March 27, 2017

RE: **Blakes Lotaburger**
1640 Gibson Blvd SE
Grading and Drainage Plan
Engineer's Stamp Date 3/27/17 (File: M15D012A)

Based upon the information provided in your submittal received 3/27/17, the Grading and Drainage Plan is approved for Grading and Building Permit with the following recommendation:

PROJECT TITLE BLAKE'S LOTABURGER 1640 GIBSON BLVD. SE ALBUQUERQUE, NEW MEXICO 87106	DRAWN BY: JEFF WOOTEN
PROJECT MANAGER JEFF WOOTEN	SHEET TITLE Grading Plan
JOB NO. 2016033	DATE 7/24/2017
SCALE AS NOTED	SHEET NO. C1.1

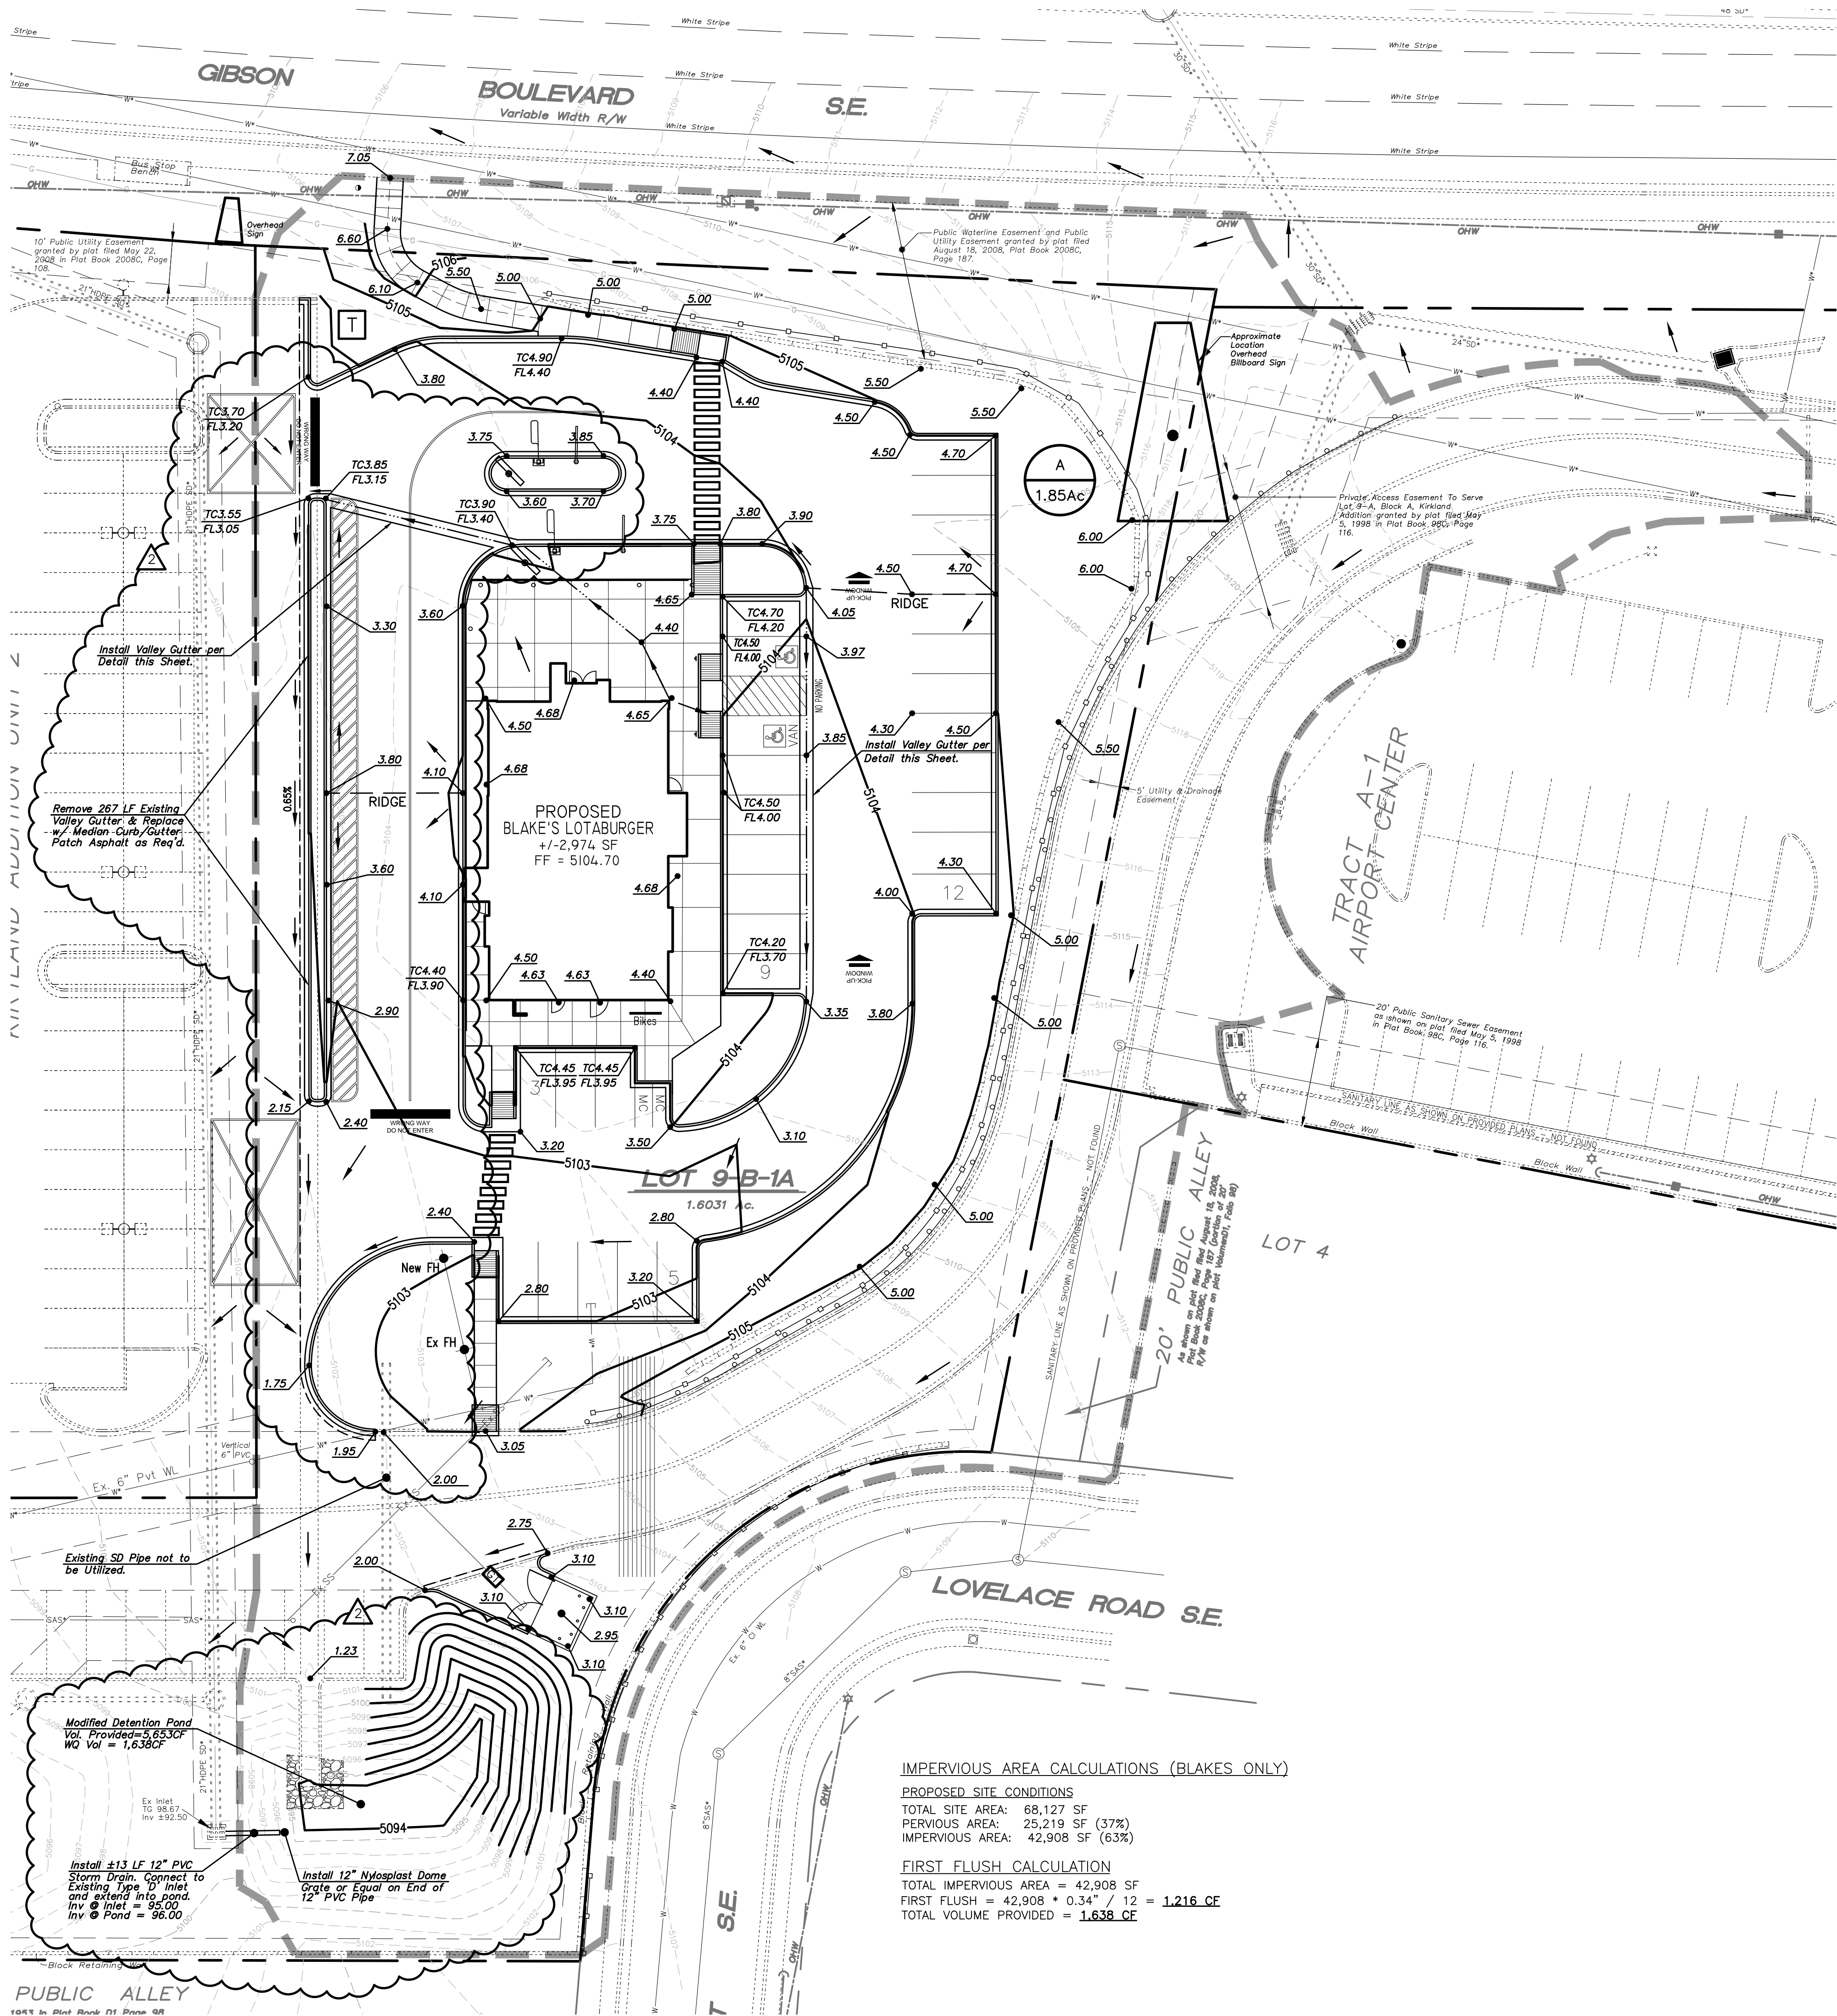
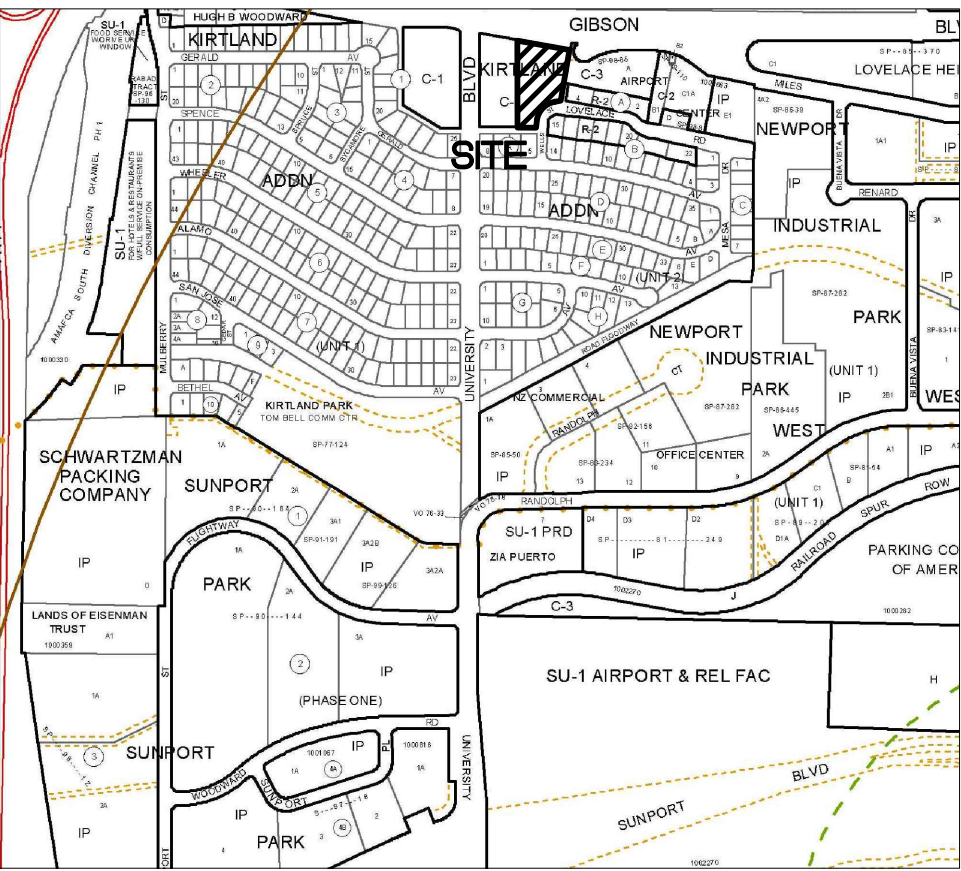
1. Provide additional curb cuts at low spots for the ponds to capture additional runoff.
